City of Portland, Maine - Building or Use Permit Application
 389 Congress Street, 04101 Tel: (207) 874-8703, Fax: (207) 874-8716

Permit No: 09-0726	Issue Date:	CBL: 378 A035001
------------------------------	--------------------	----------------------------

Past Use: Single Family	Proposed Use: Single Family / Amendment to permit #090573 changing the 12' x 26' deck to 12' x 28' with a double beam support.	Permit Fee: \$50.00	Cost of Work: \$2,800.00	CEO District: 5
Proposed Project Description: Amendment to permit #090573 changing the 12' x 26' deck to 12' x 28' with a double beam support.		FIRE DEPT: <input type="checkbox"/> Approved <input type="checkbox"/> Denied	INSPECTION: Use Group: Type	
		Signature: _____		Signature: _____
PEDESTRIAN ACTIVITIES DISTRICT (P.A.D.)				
Action <input type="checkbox"/> Approved <input type="checkbox"/> Approved w/Condition <input type="checkbox"/> Denied				
Signature: _____ Date: _____

PLOT PLAN

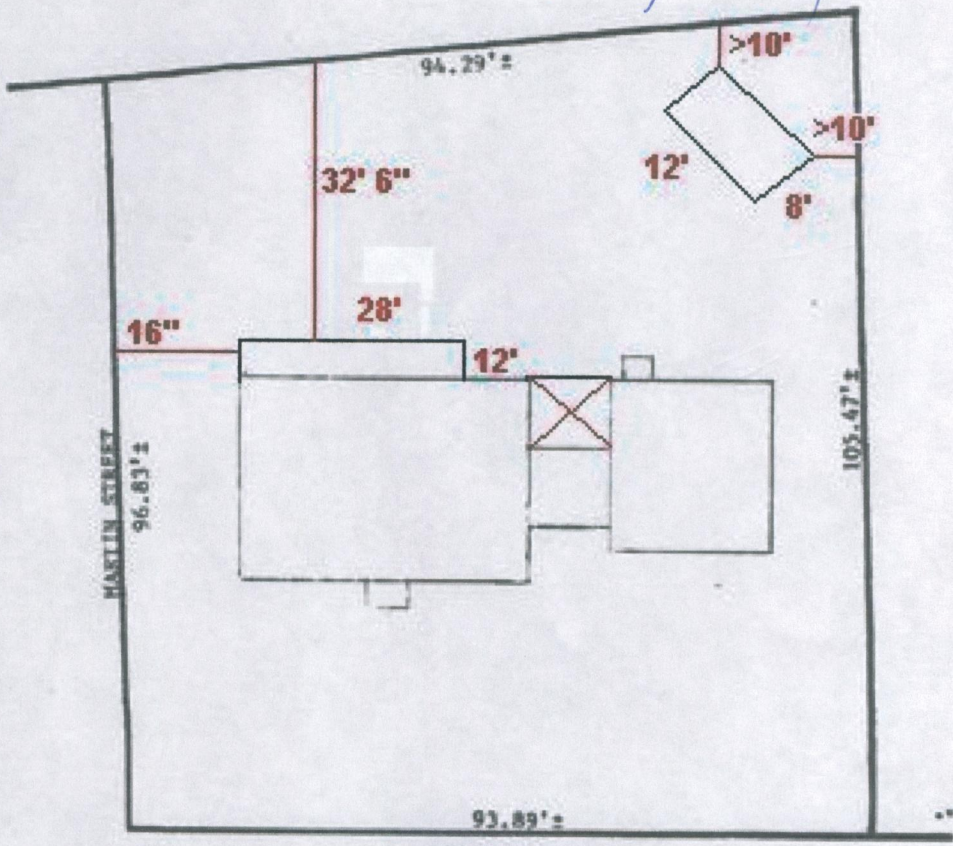
Comments:
7/14/2009-mes: The previous permit was zoned wrong - it is an R-2 Zone not an R-3 zone - called owner to confirm the deck is being enlarged from 12' x 26' to 12' x 28'.
7/15/2009-mes: applicant confirmed the larger deck and the new structural work
